CITY OF PORTLAND

BUILDING PERMIT

Located At 45 TIDE MILL RD

Job ID: 2012-05-4074-SF

SEE SHEET 1 FOR NOTES,
 LEGEND AND LOCATION MAP

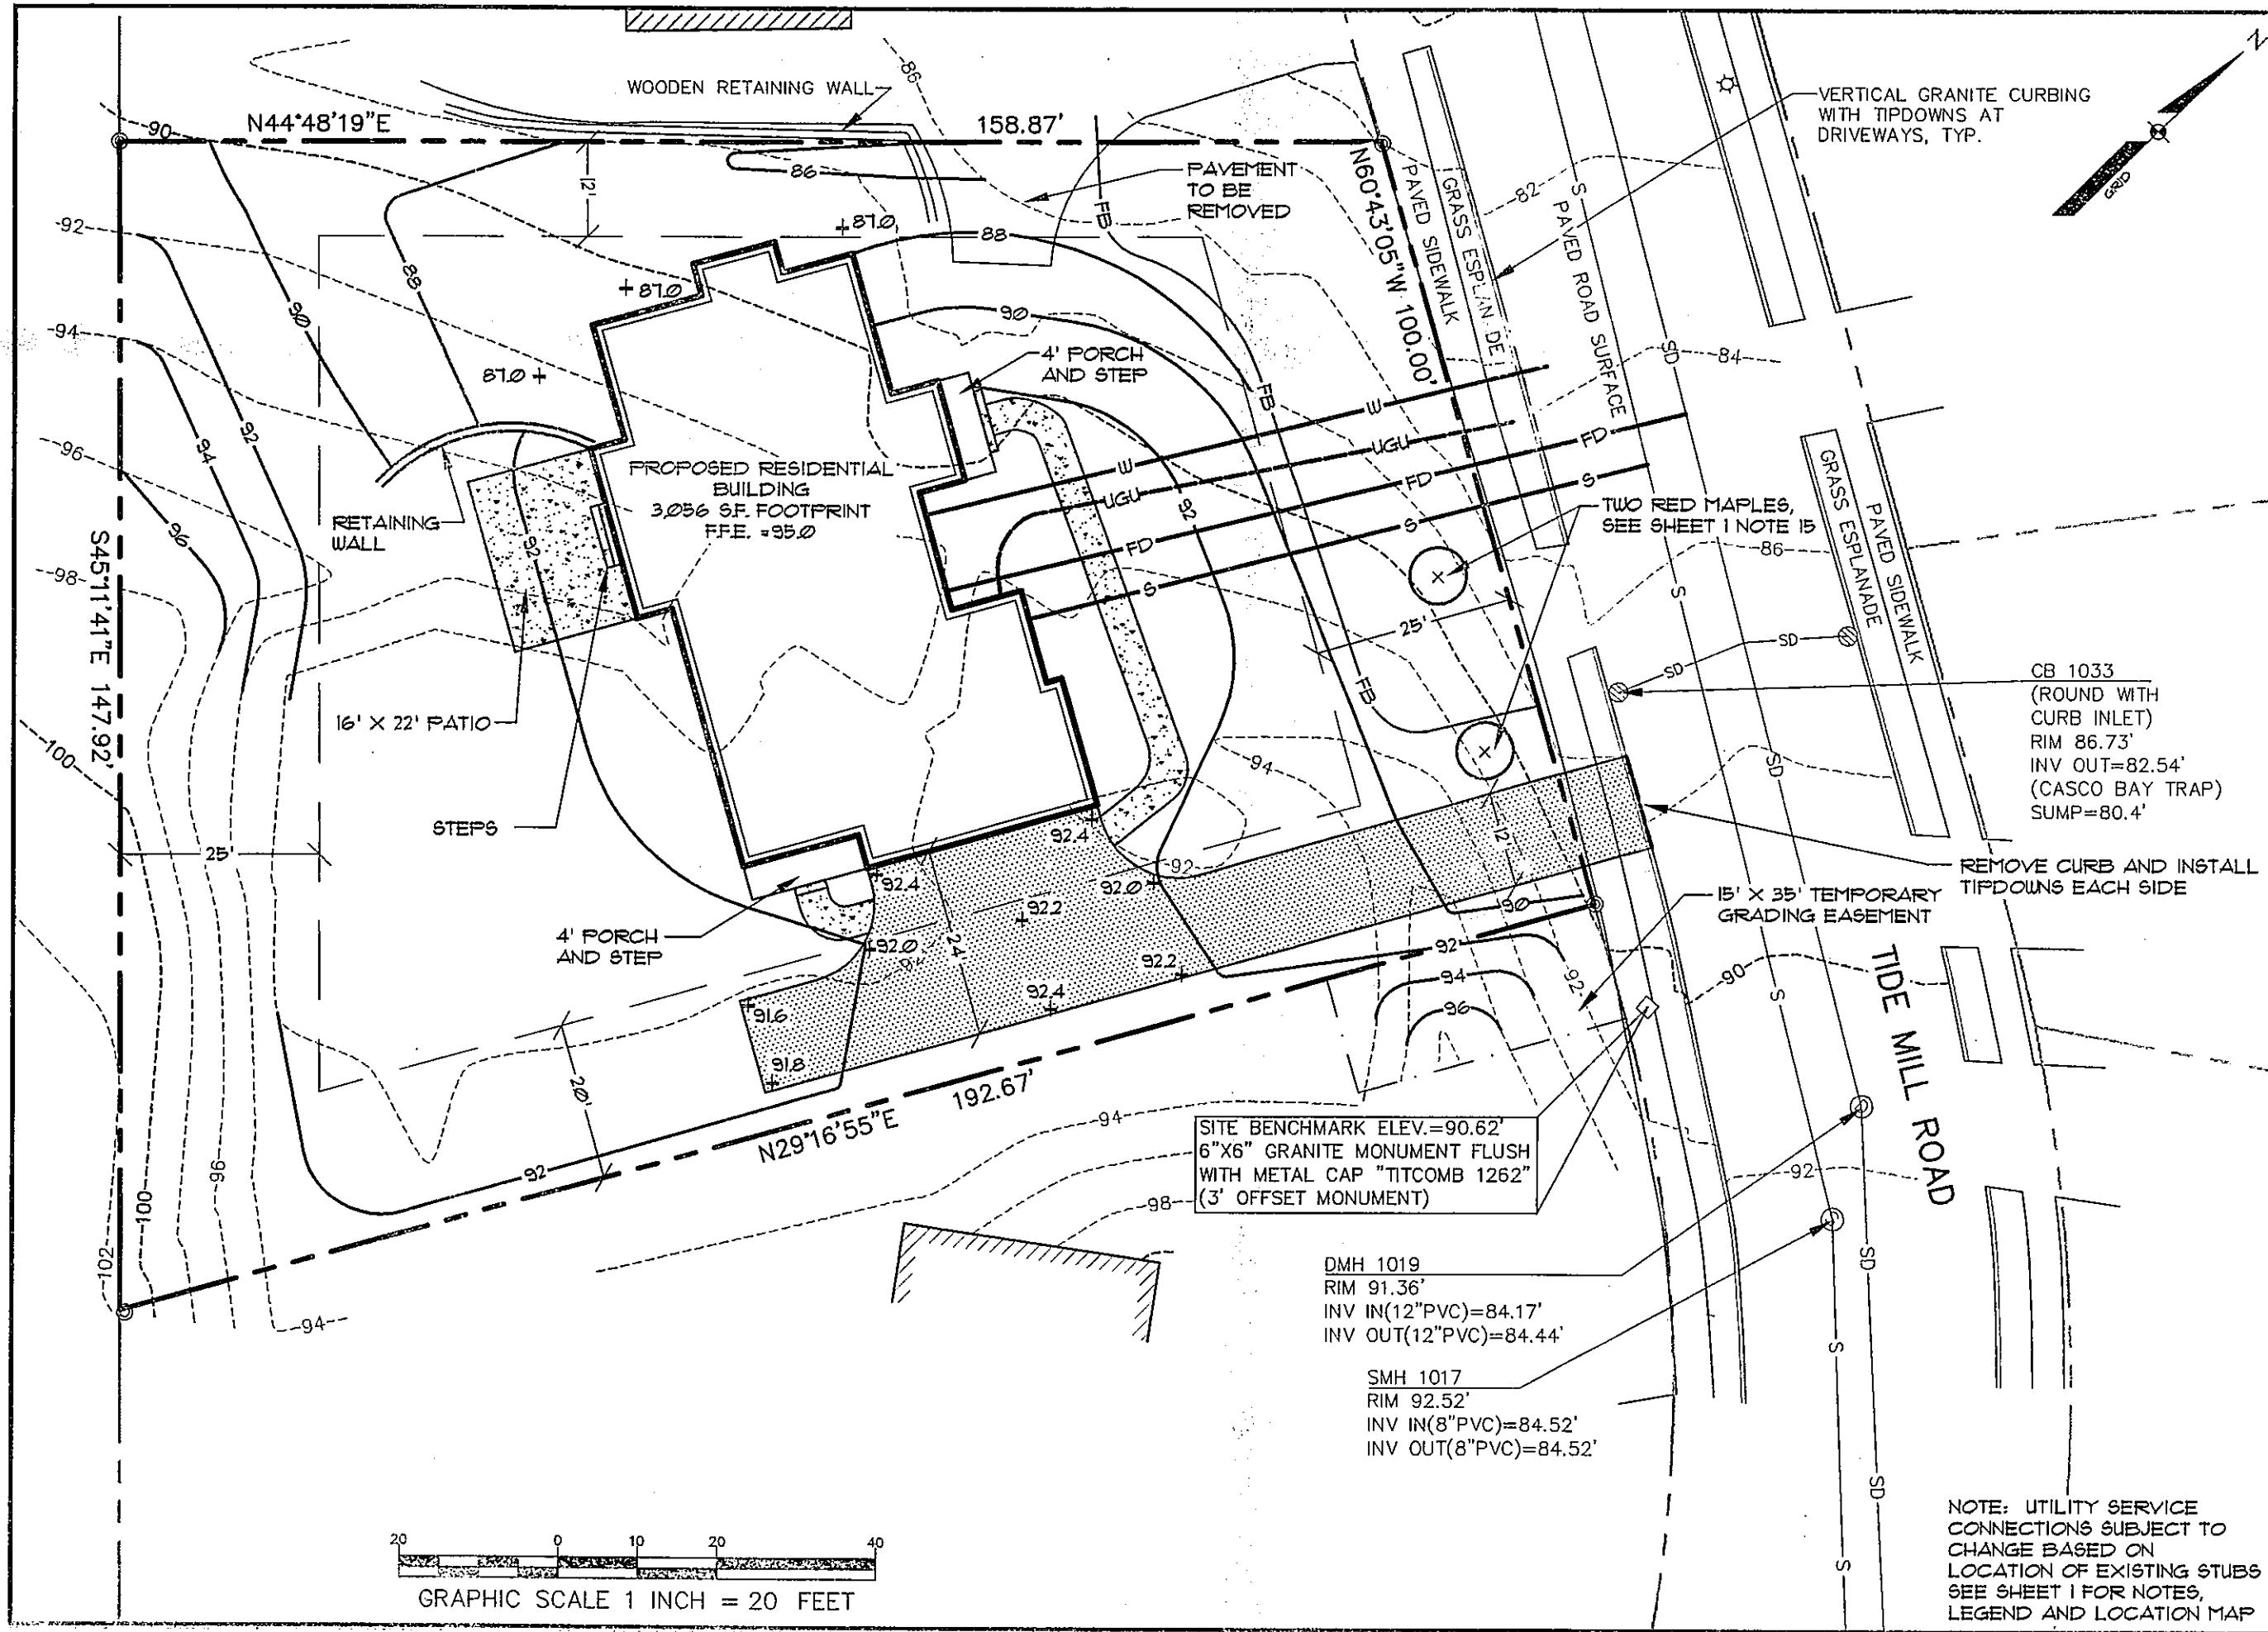
12. Prior to the construction of the retaining wall, a detail of the wall must be submitted for review and approval by the Planning Department. The wall may have to be designed and stamped by an engineer, and include plans and details.
